**Addendum No. 4**

RE: Contract # C204039

**Polk County (I-4729A)**

I-26/US-74/NC-108 Interchange Modifications in the Town Of Columbus

CULVERT SECTION NORMAL TO ROADWAY

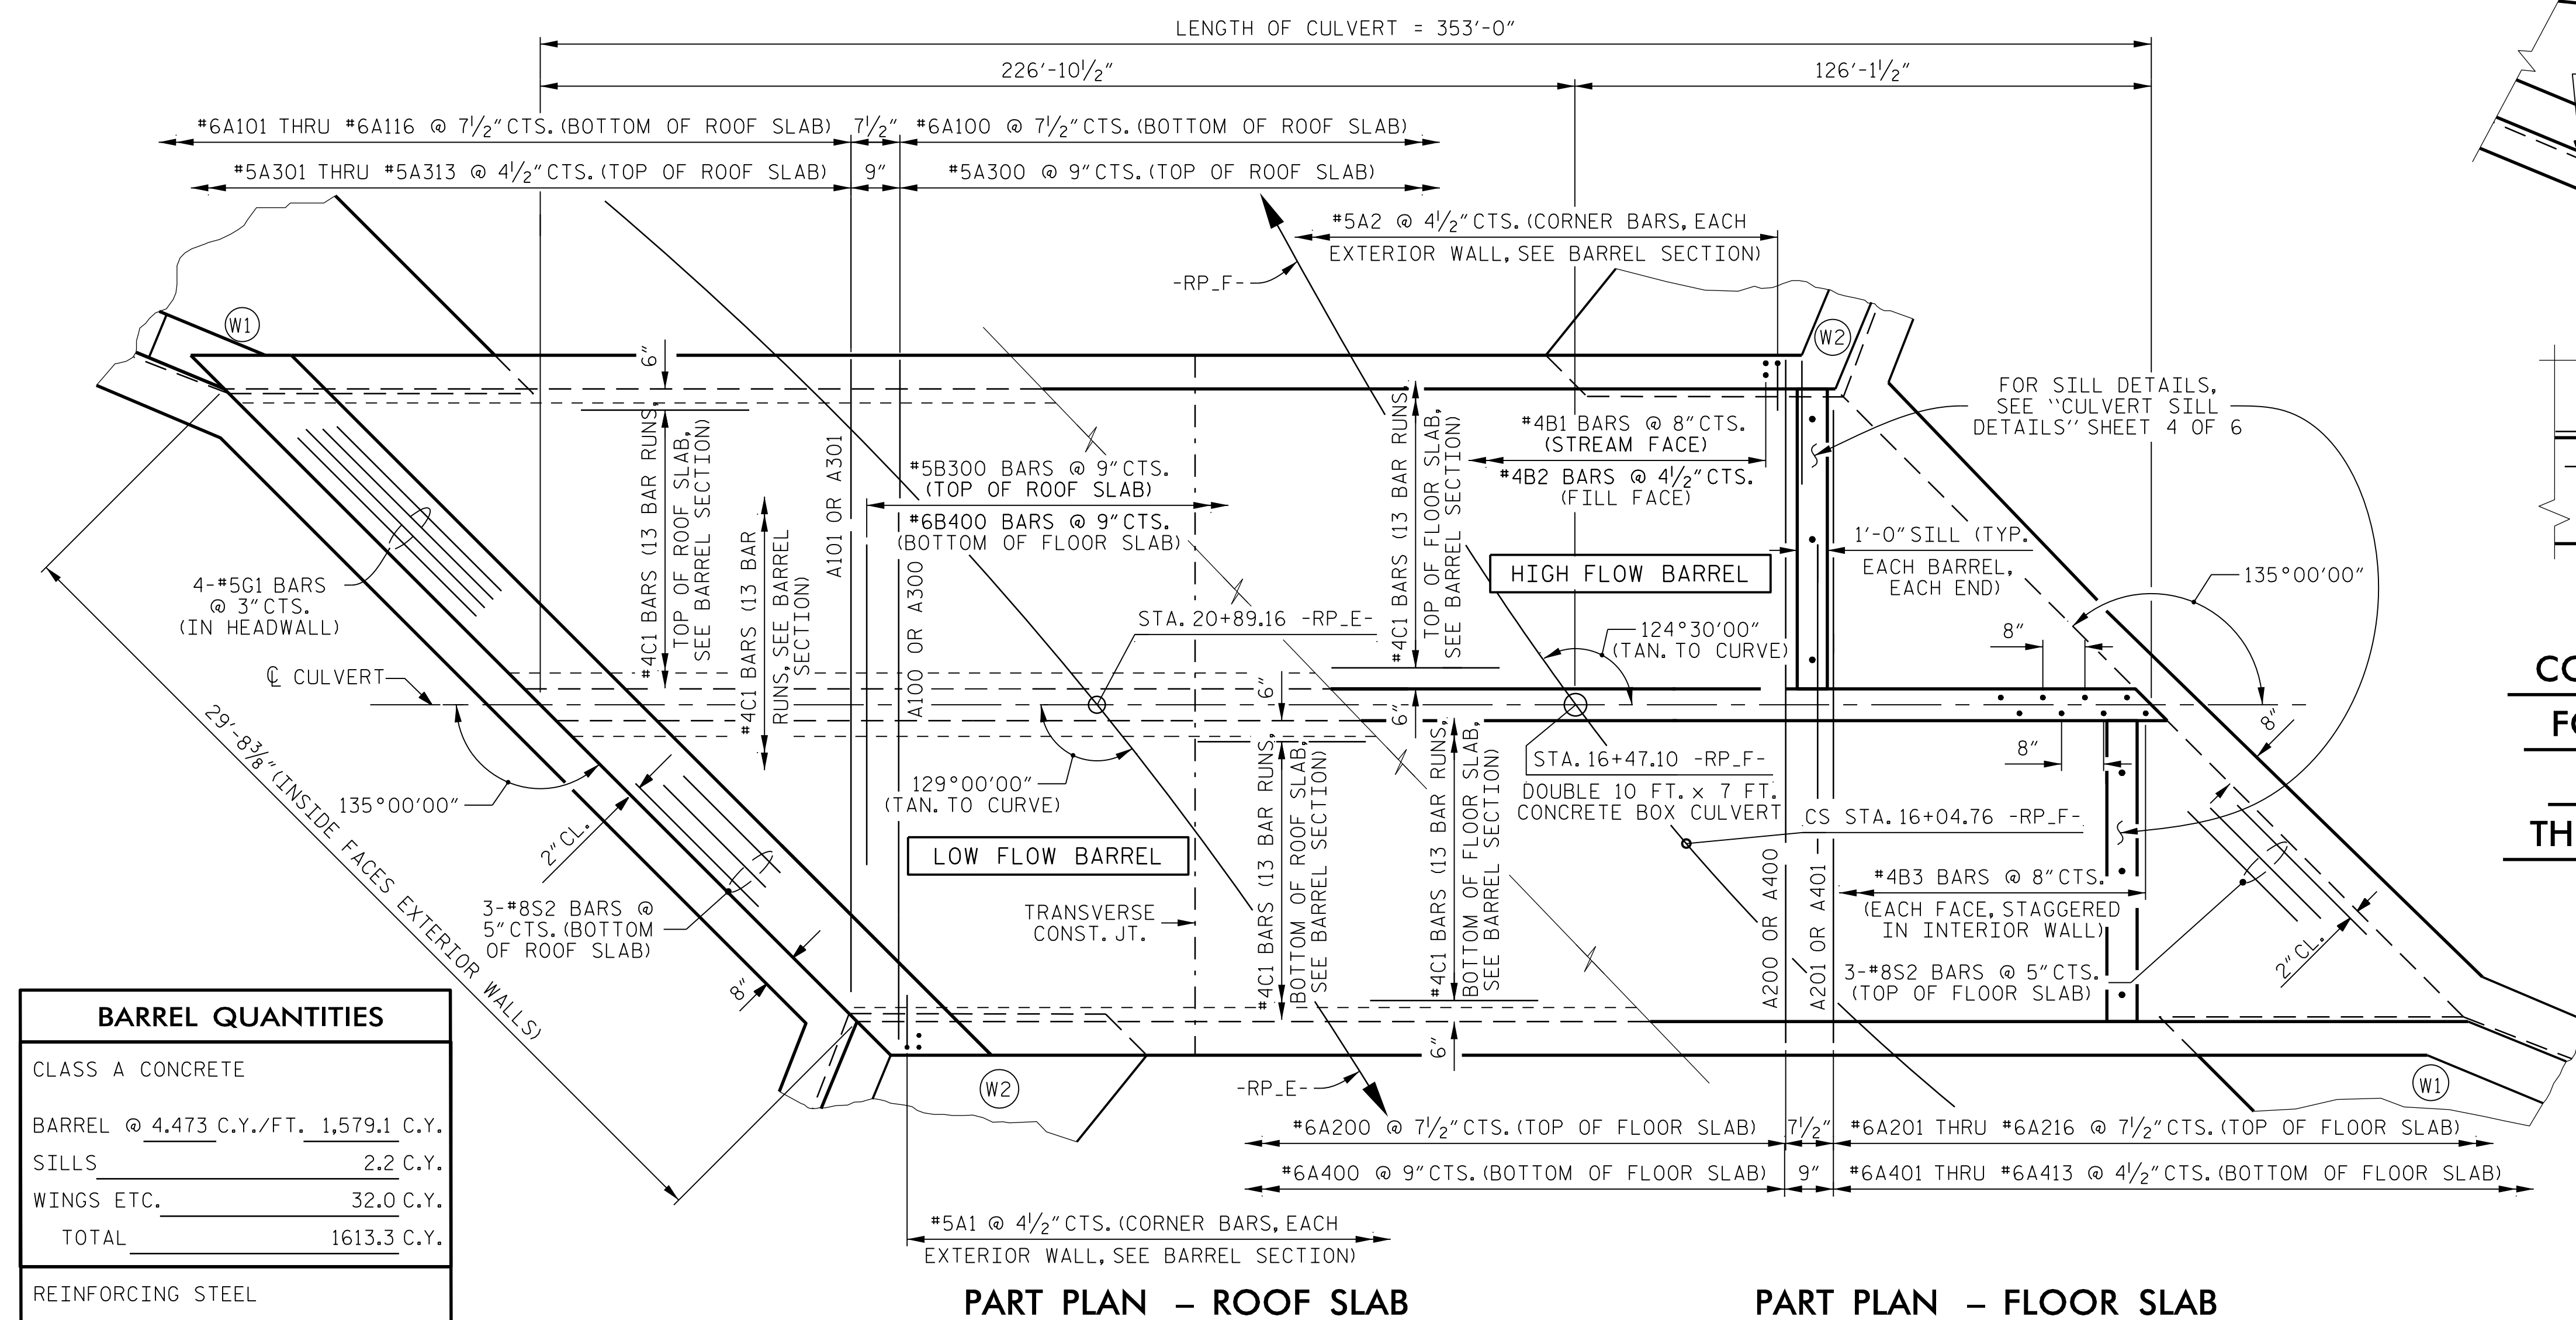
Sheet No.	Revisions
C-1	Note added to allow Precast option

Please void existing Sheet C-1 in your plans and staple the revised Sheet C-1 thereto.
